## MEMORANDUM

**Subject:** Application ID: 2016-016

**Comments Submitted by: Keith Gautreau/Fire on 8/17/2016**

DRAWN BY  
 SHEET TITLE  
**Existing Conditions & Removals Plan**

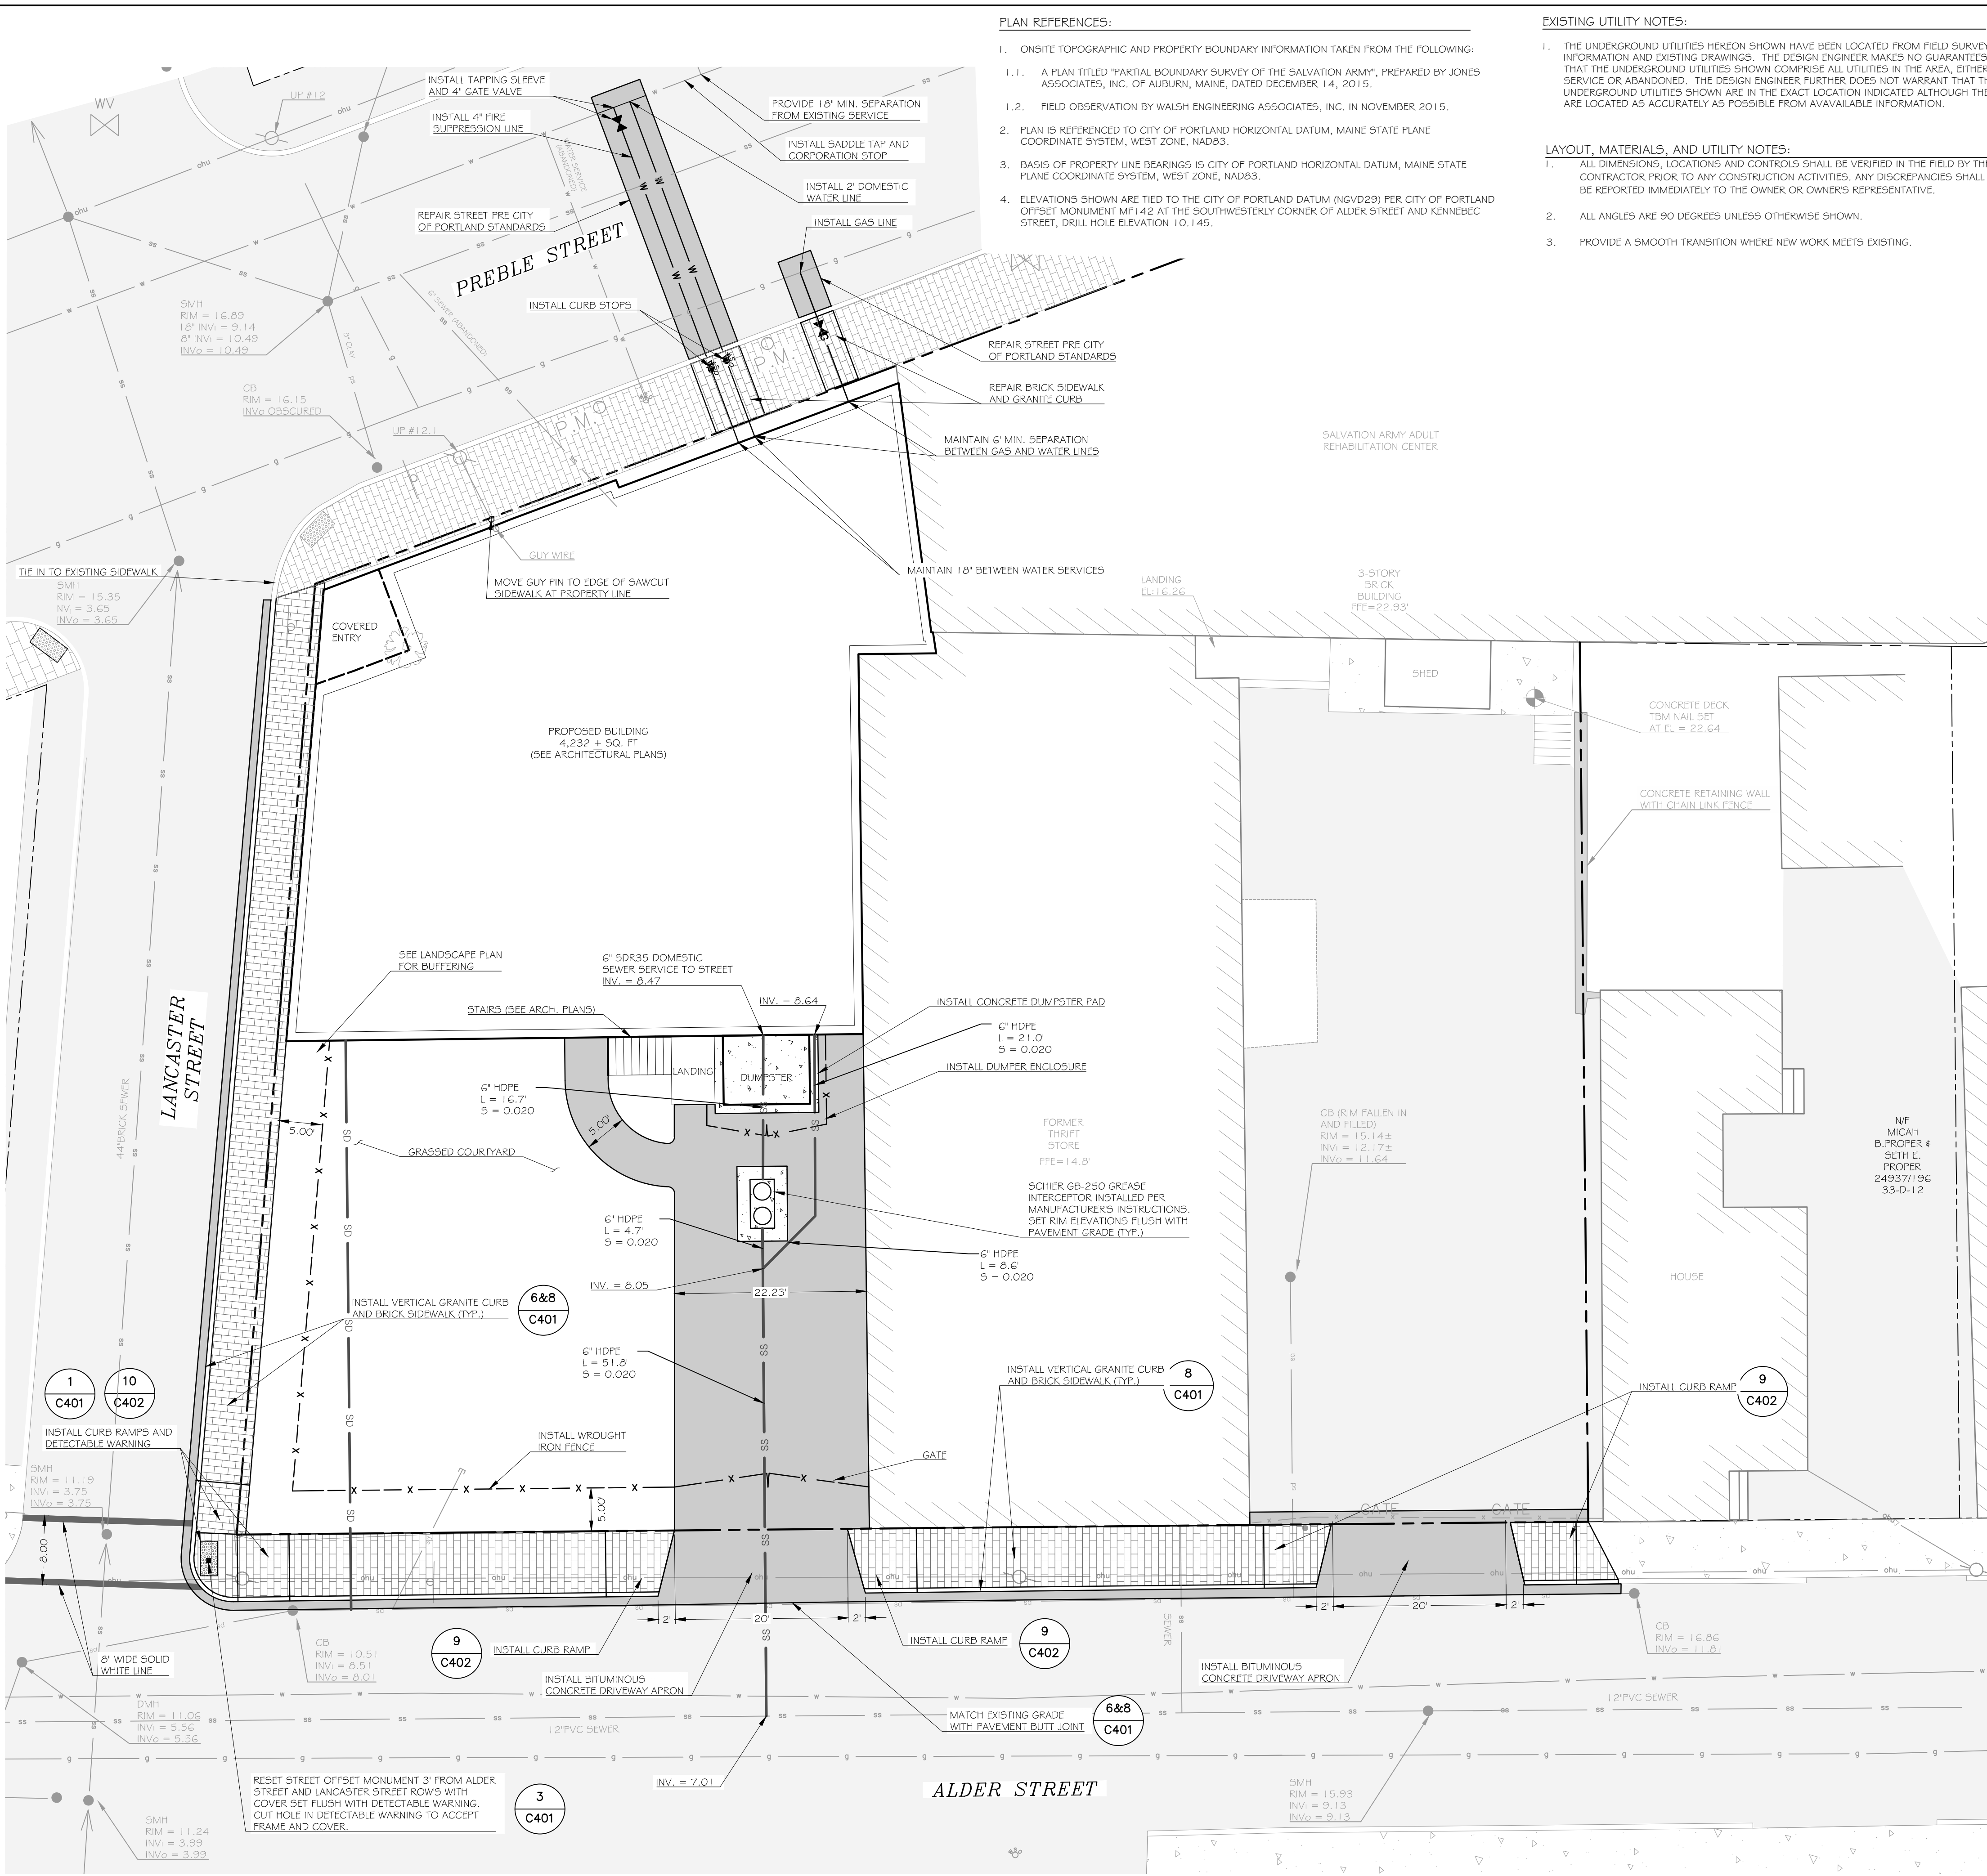
The revised plans show excellent Emergency Access on the corner of Alder and Lancaster. Water supply from the public hydrants in the area will be sufficient for the proposed one story addition.
